DELEGATED DECISION TO DETERMINE PLANNING APPLICATIONS

Reference No:	2025/62/91655/E
Site Address:	168, Mill Lane, Birkenshaw, BD11 2AP
Description:	Demolition of existing rear extension and erection of replacement single storey rear extension and associated alterations
Recommending Officer:	Jennifer Booth

OFFICER REPORT

MATERIAL SCHEDULE

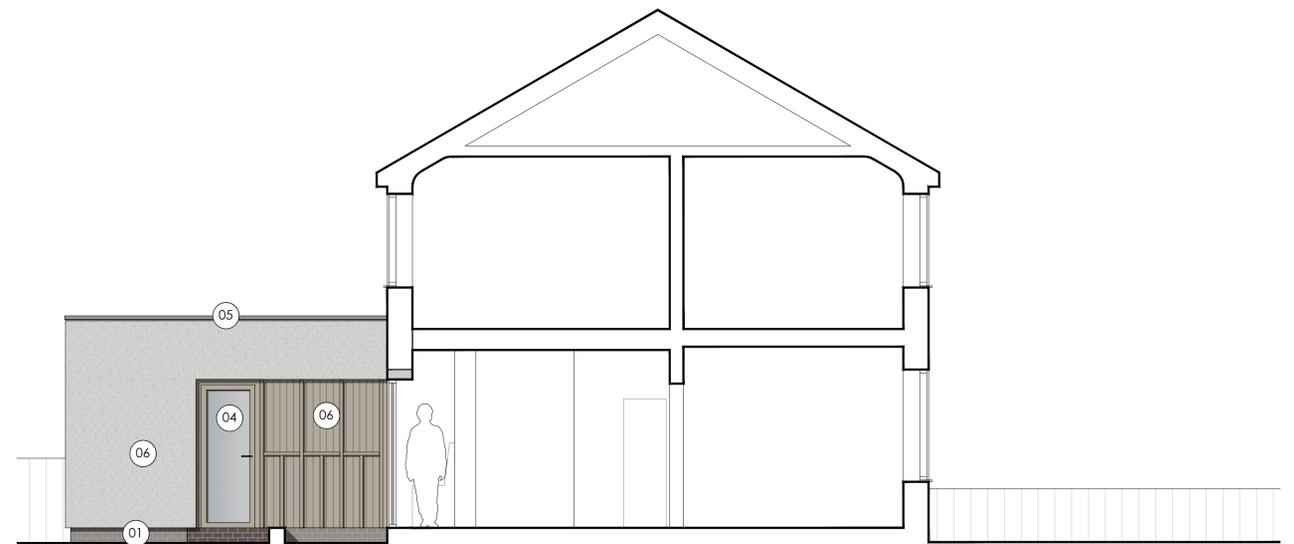
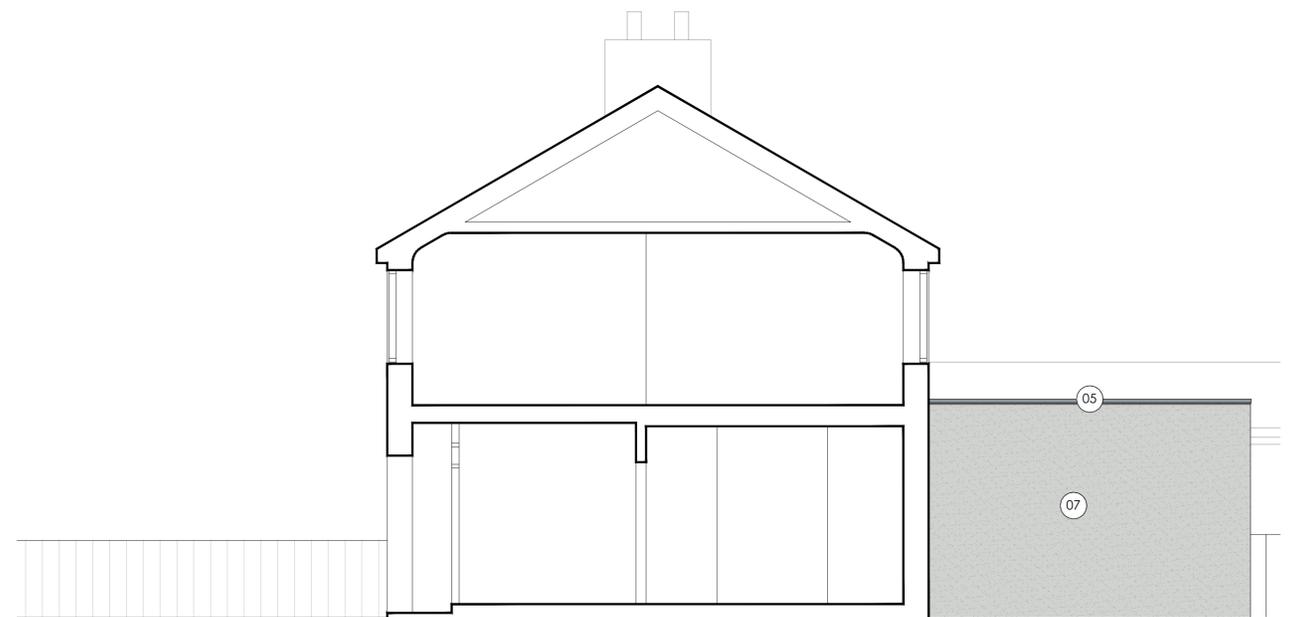
Matching materials with the exception of the timber detailing shown on the submitted plan, to ensure that the extension harmonises with the host property as using alternative materials would look out of place within the street scene.

The initially submitted plans raised concerns in terms of the materials and appearance. Amended plans have been provided which altered the materials. As the alteration did not increase the development, the amended plans have not been advertised.

3. With the exception of the timber detailing shown on the submitted plans, the external walls of the extension hereby approved shall in all respects match those used in the construction of the existing building.
